**From:** Nicola Spencer on behalf of Planning.Responses  
**Sent:** 01 December 2025 14:12  
**To:** Planning Scanning  
**Subject:** FW: Planning Consultation on: BR/197/25/PD Allestree Court Walton Road Bognor Regis PO21 1NN

PL- Consultation- West Sussex Fire response

**Application No:** BR/197/25/PD  
**Registered:** 14th November 2025  
**Site Address:** Allestree Court Walton Road Bognor Regis PO21 1NN  
**Grid Reference:** 493971 99111  
**Description of Works:** Application for prior approval under Schedule 2 Part 20 Class A for the construction of one additional storey creating 2 No. additional dwellings.

PROPOSED THIRD FLOOR

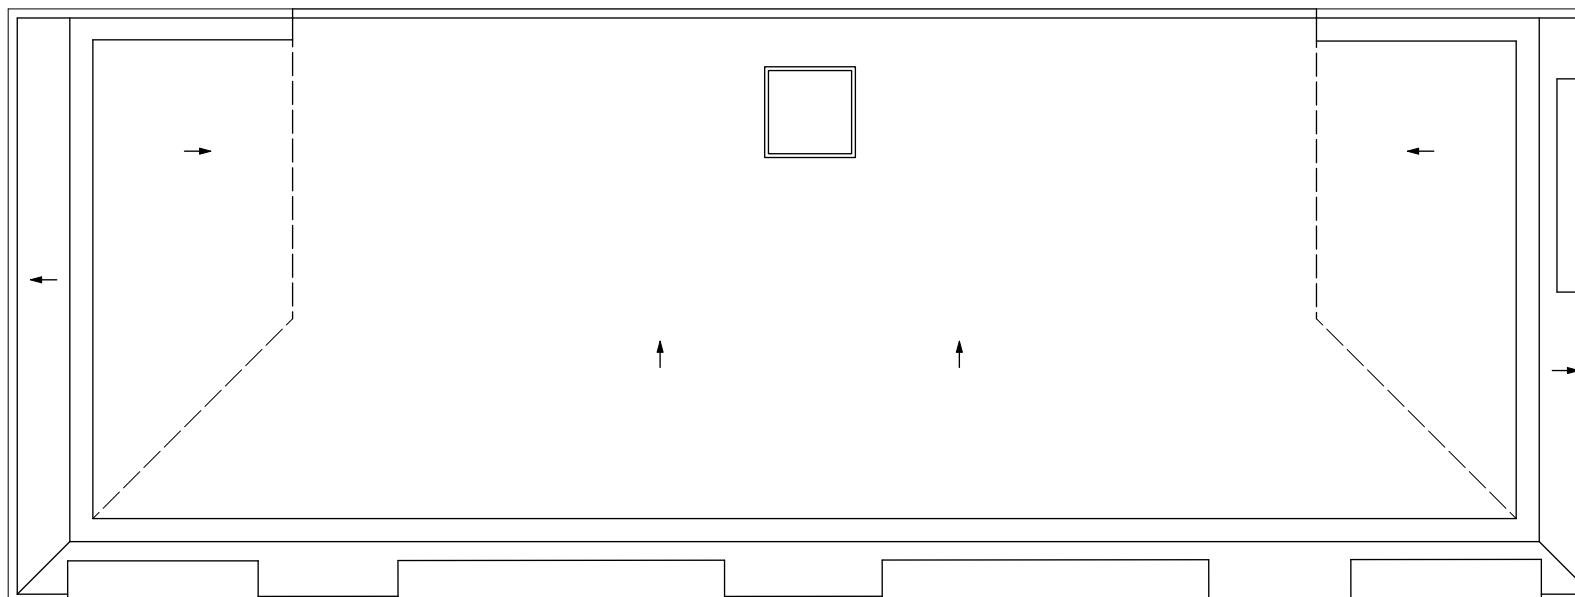
Having viewed the plans for the planning application no. BR/197/25/PD for prior approval under Schedule 2 Part 20 Class A for the construction of one additional storey creating 2 No. additional dwellings; evidence is required to show that all parts inside all dwellings are within 45 metres of the location of a fire appliance or the dry riser outlet in accordance with Approved Document B (AD-B) Volume 1 B5 section 13. This is to be measured along the hose lay route, not in a direct line or arc measurement. Any areas not within the 45m distance will need to be mitigated by the installation of domestic sprinkler or water mist systems complying with BS 9251 or BS8458 Standard.
